November 16, 1998

RE: ENGINEER CERTIFICATION FOR FUDDRUKER'S (F17-<sup>D80</sup>~~D71~~) CERTIFICATION  
STATEMENT DATED 10/20/98

# DRAINAGE INFORMATION SHEET

***RE: FUDRUCKER'S (F17-~~DEF~~). GRADING AND DRAINAGE PLAN FOR BUILDING  
PERMIT APPROVAL. ENGINEER'S STAMP DATED NOVEMBER 12, 1997.***

GRADING AND DRAINAGE PLAN

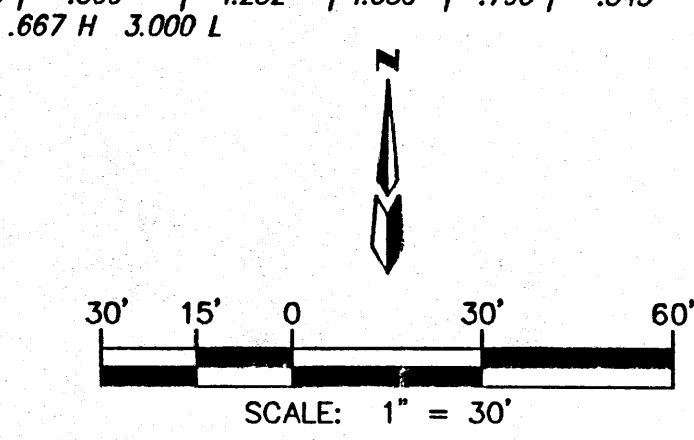
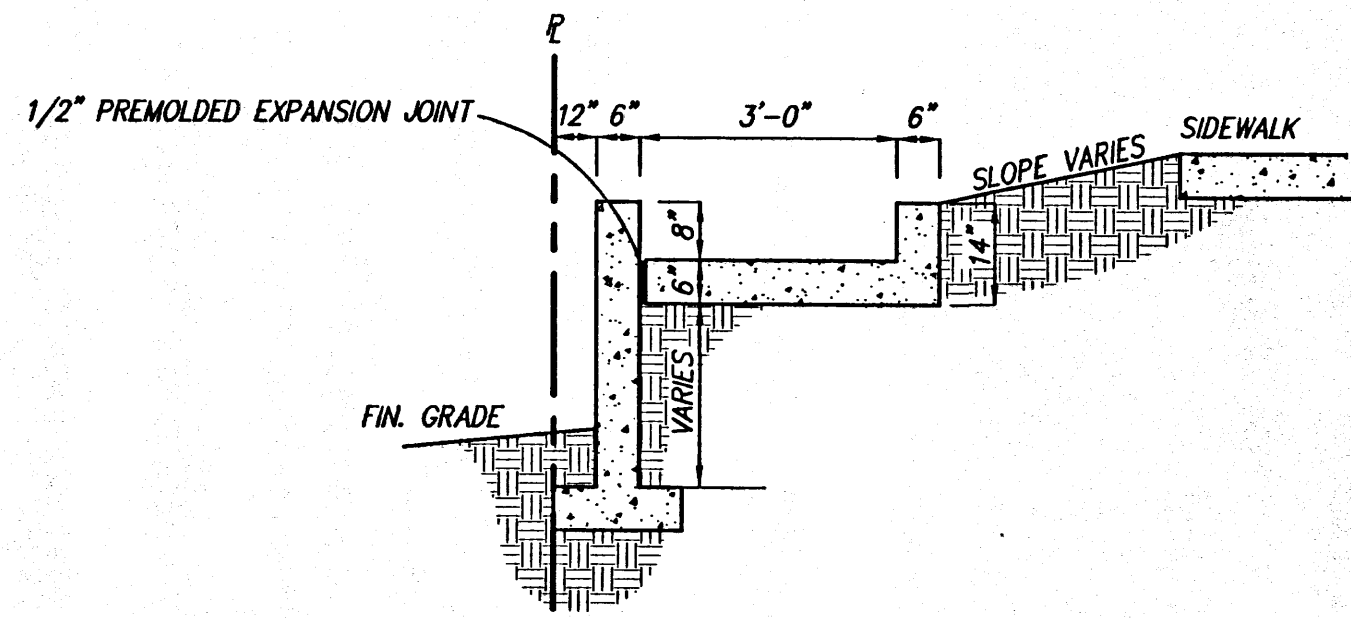
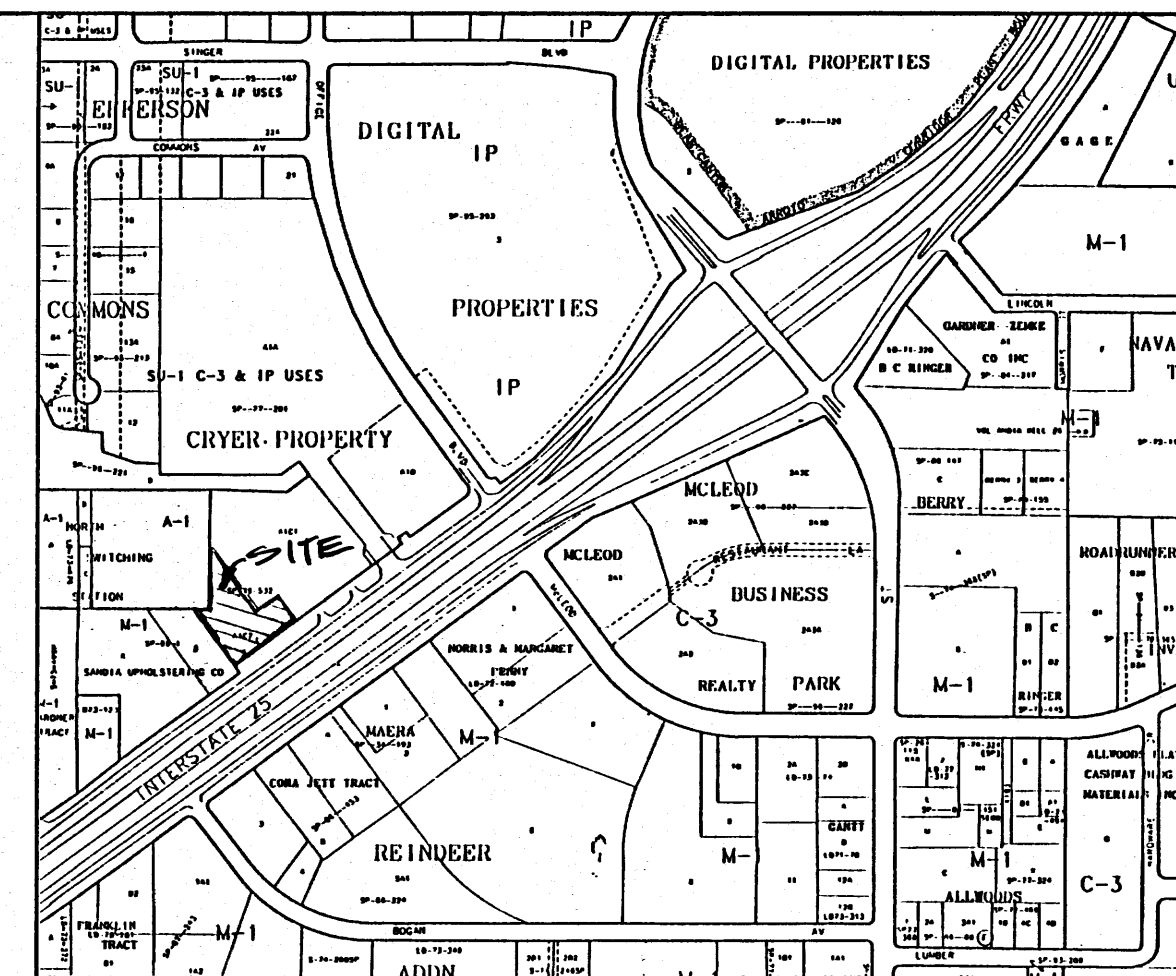
1. What numbers are you using in your weir equations (Basins A and B) for length and height?
2. What is downstream capacity and allowable discharge?
3. What is historical discharge?
4. Please provide a general explanation of the project and define what happens to flow once it leaves the site.

- Comment #1- The weir equation variables which were used are shown on the plans drainage information legend.
- Comment #2- The site discharges to a preexisting bar ditch located along the I-25 frontage road. This ditch currently conveys the developed storm discharge for one half of the road for approximately 2300 feet. This offsite basin is shown on the attached orthophoto topographic map. This basin has a predicted 100 year developed flow discharge of 9.07 cfs. The bar ditch has an average depth of 2 feet. The attached calculations show that the bar ditch needs to be 18" deep to adequately convey the existing flows and the additional flows generated from the development of this site. The bar ditch discharges to an existing inlet where it enters an 24" CMP that out falls to the AMAFCA North diversion Channel. The attached calculations show all the down stream facilities are adequate to properly convey the 100 year developed storm runoff to the AMAFCA North Diversion Channel.

- Comment #3- The historical discharge rate is 2.29. The site currently discharges upon an adjacent westerly parcel.
- Comment #4- The development of this site corrects the adverse drainage pattern which currently occurs. The developed storm runoff is directed to a landscaped channel running along the western boundary of the site. This channel carries the flow to a preexisting bar ditch running along the northern edge of the I-25 frontage road. This bar ditch will convey the flows generated from 1/2 of this road and the additional runoff from this site to an inlet located adjacent to the AMAFCA North Diversion Channel. The attached calculations show the development of this site is designed with excepted engineering practices and the down stream facilities are adequate to accommodate the development.

FUDDRUCKER'S
GRADING AND DRAINAGE PLAN

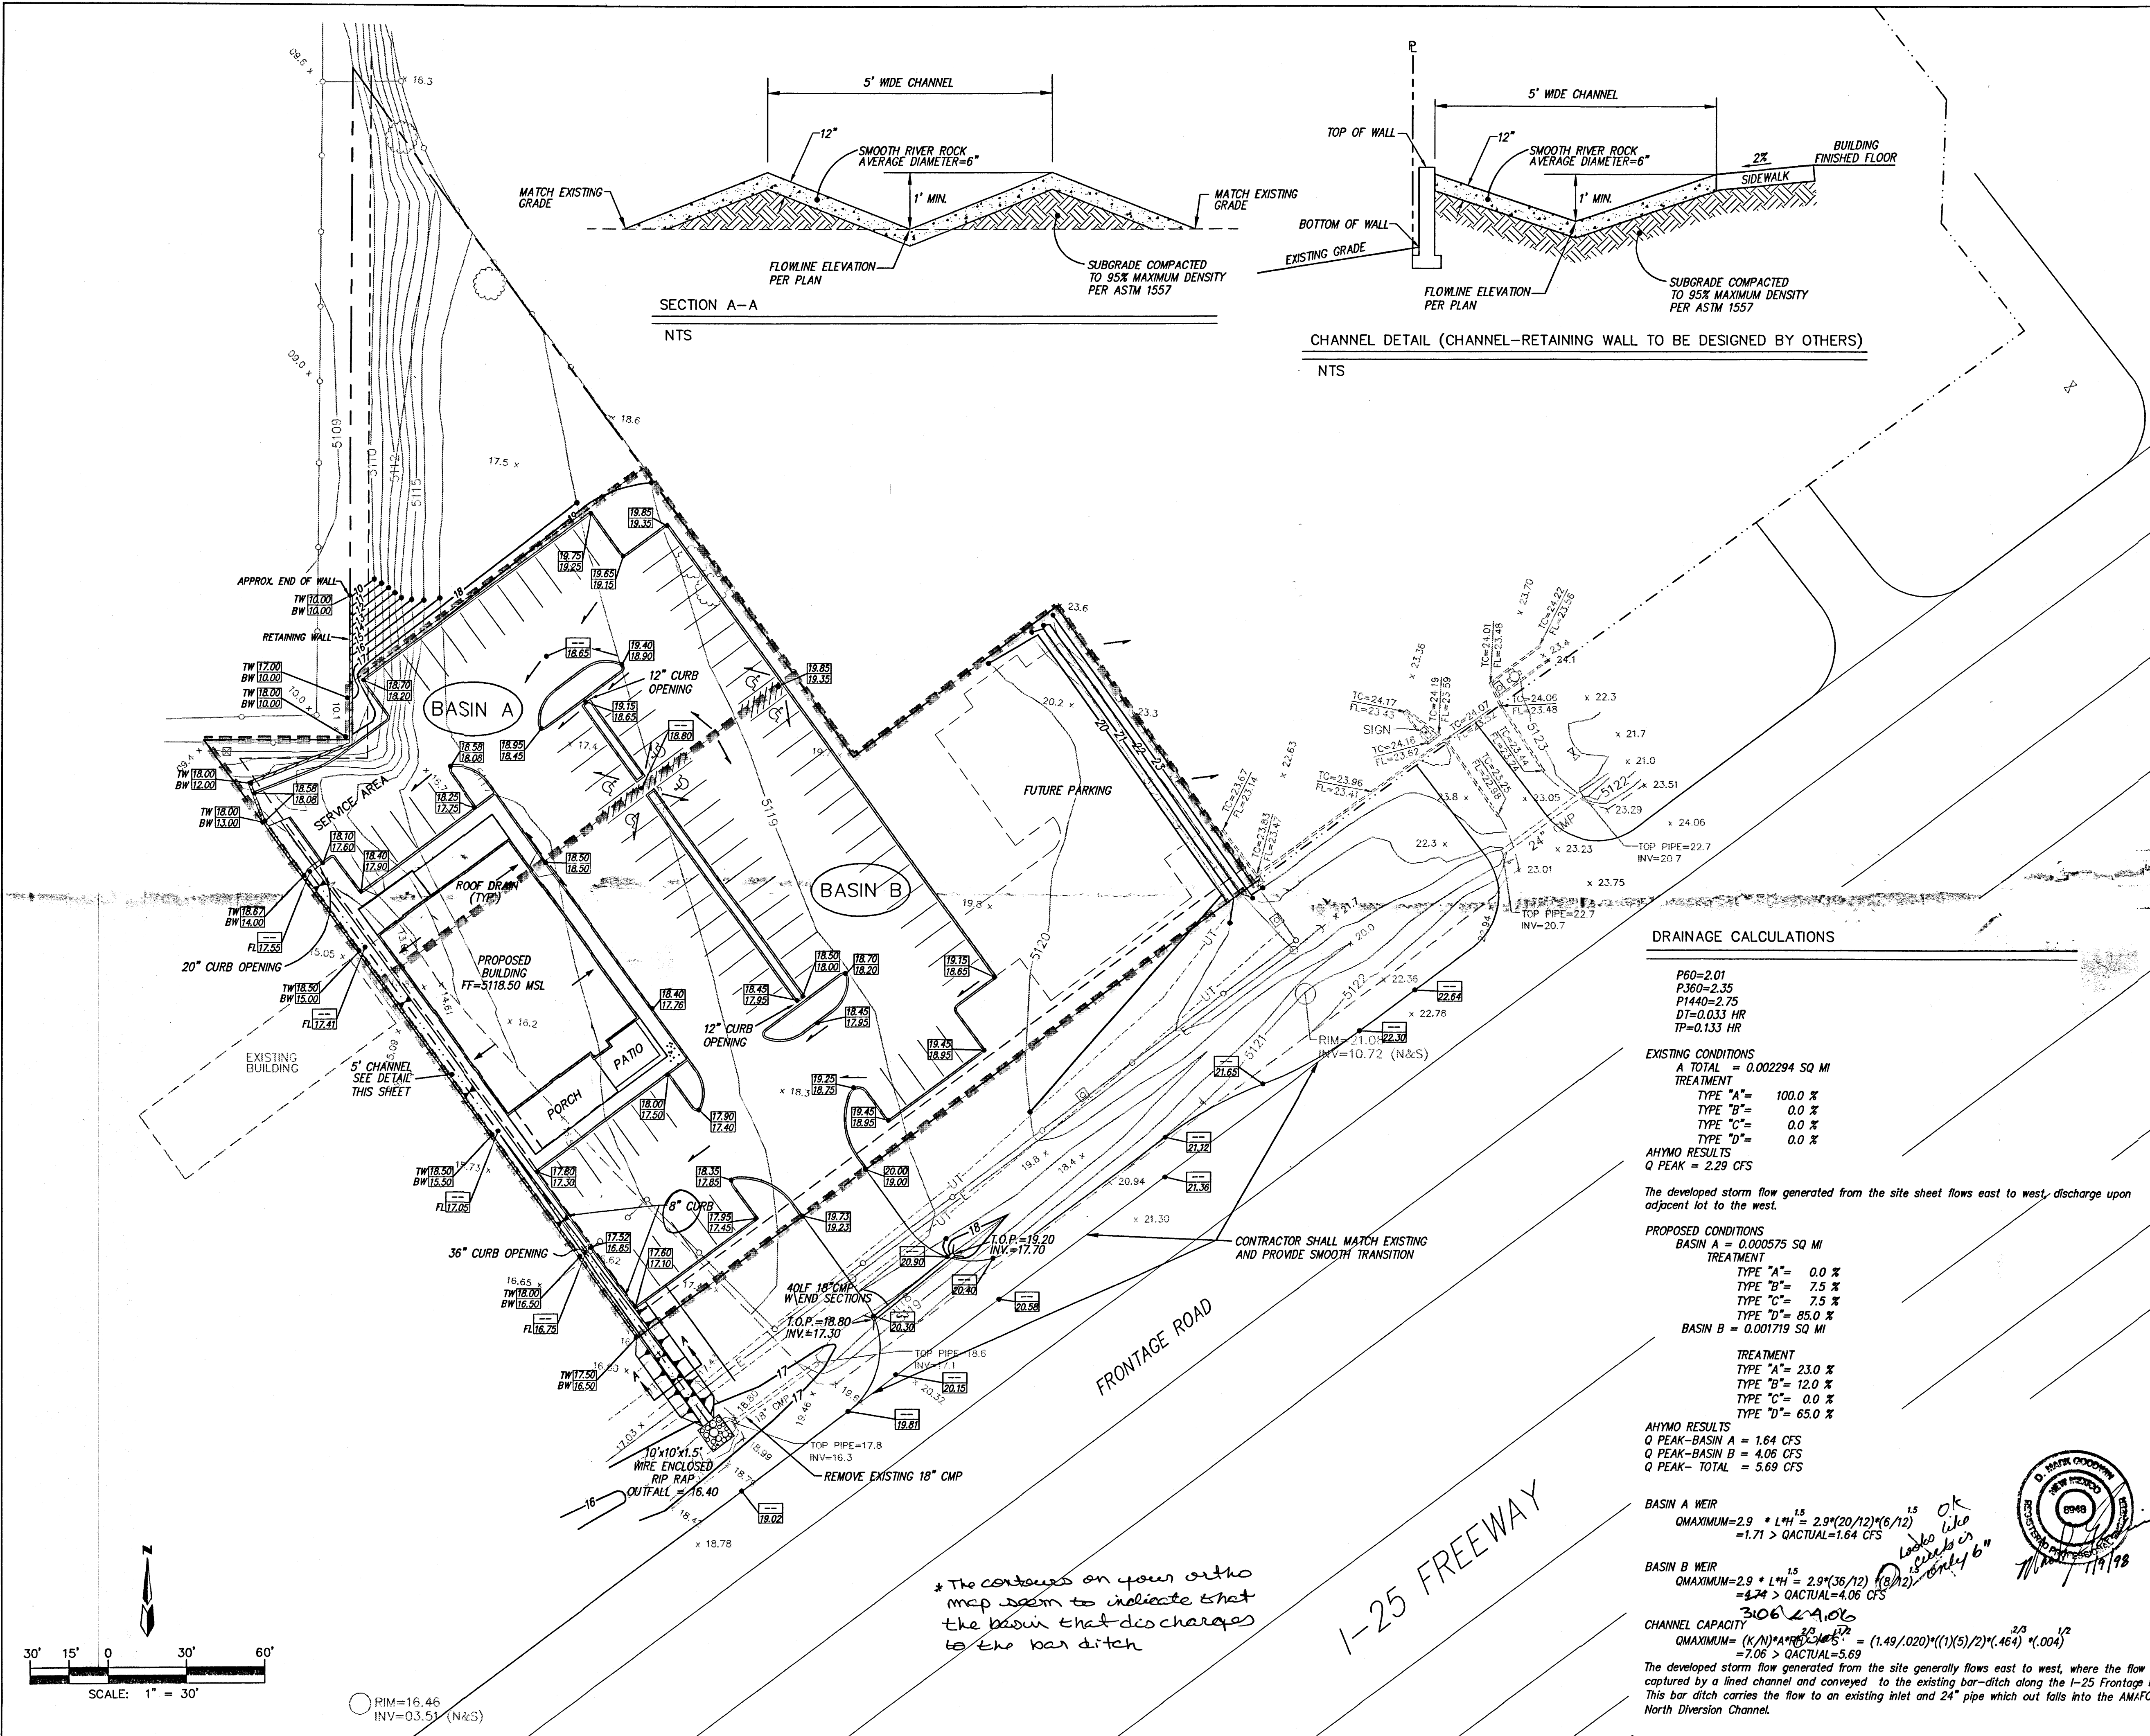
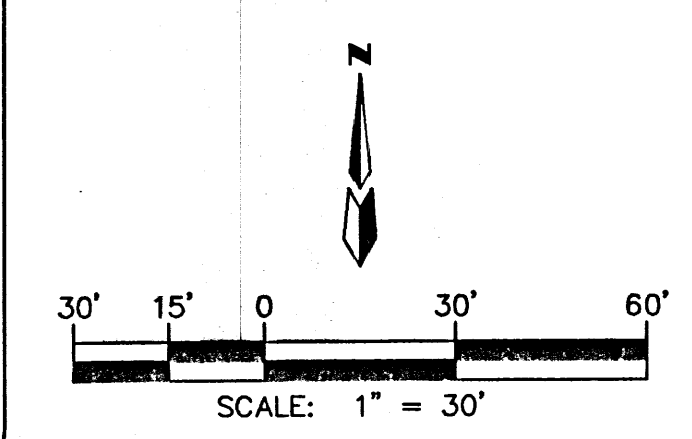
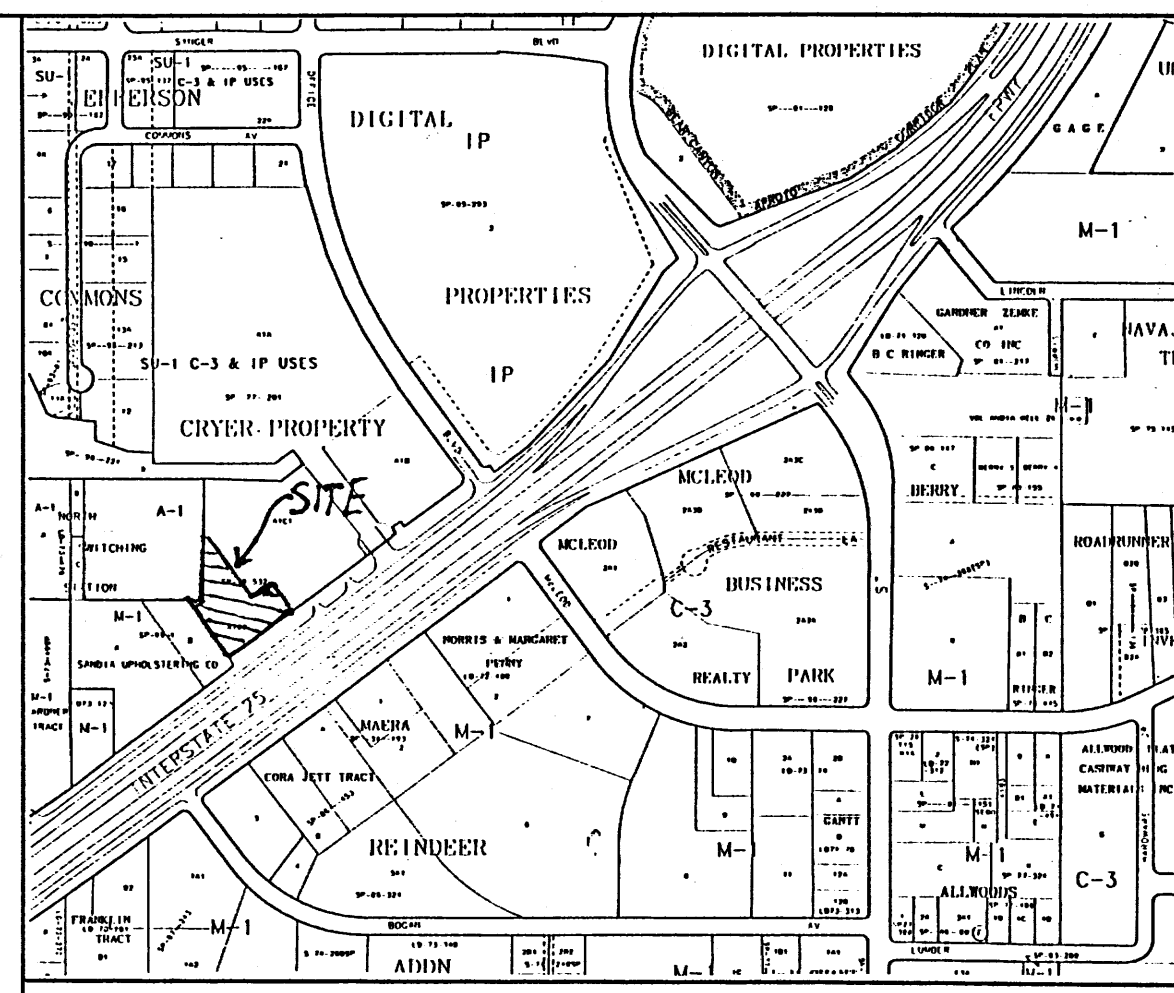
1. Your orthophoto topographic map seems to indicate that properties north of the Frontage Road drain to the bar ditch. You must consider these flows when determining the allowable discharge from your site. In other words, it appears that your allowable discharge will be somewhat less than the capacity of the channel.
2. Please re-evaluate the equation used to determine the channel capacity. I do not think the "H" variable belongs in the equation.
3. Concurrence from the New Mexico State Highway Department will be required.

- Comment #1-Attached is a more defined orthotopographic map showing the drainage basin which drains to the bar-ditch in front of this site. The properties which front bar-ditch drain mainly east to west. Only a small portion of each lot drains to the bar-ditch. After re-analyzing the basin, I find the developed flow to be 9.27 CFS. With the contribution of the flow from our site, the capacity of the channel is sufficient to carry all the predicted developed storm discharge to the existing inlet located within the I-25 frontage right of way.

- Comment #2- The formula for the channel capacity does not include the variable H, the variable is R<sub>h</sub> for hydraulic radius. The confusion was in the letter sizing, the revised plan corrects this issue.

- Comment #3- We are in the process of obtaining acceptance of this drainage plan from the New Mexico State Highway and Transportation Department.
